Planning Application Ref: AB/102/20/T

Location: Riverside House, 2 Fitzalan Road, Arundel, BN18 9JS

Description of works: Various works to various trees

Location Plan
 2 Fitzalan Road
 Arundel
 BN18 9JS
 Scale: 1/1250

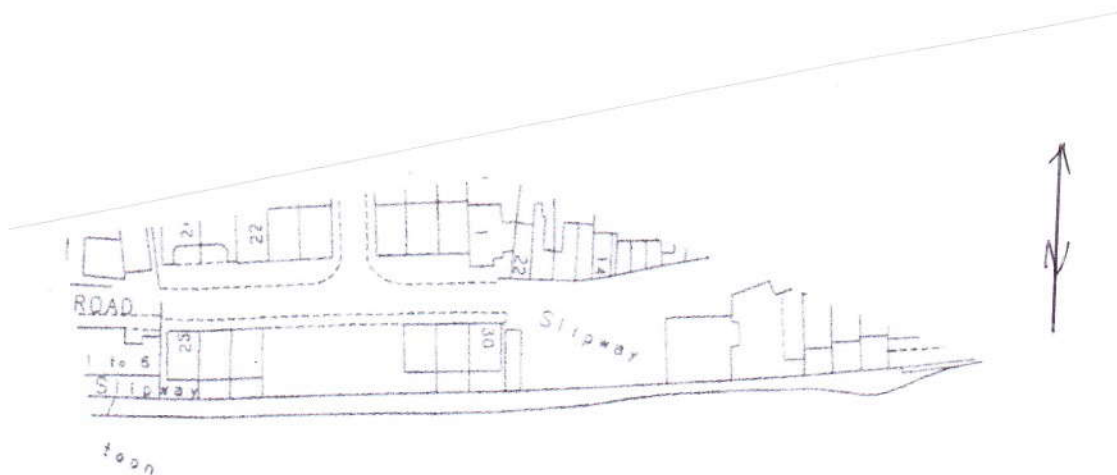
- I saw no oak tree at the location marked on the plan or in the immediate area. An established off-site bay laurel (TPO/AB/3/93) may have been mistakenly identified as holm oak? In any event, I find the extent of reduction pruning proposed has not been justified and exceeds the requirements of British Standard (BS3998:2010) Tree work – Recommendations.

- I saw no established tree of that genus at the location marked on the plan or in the immediate area.
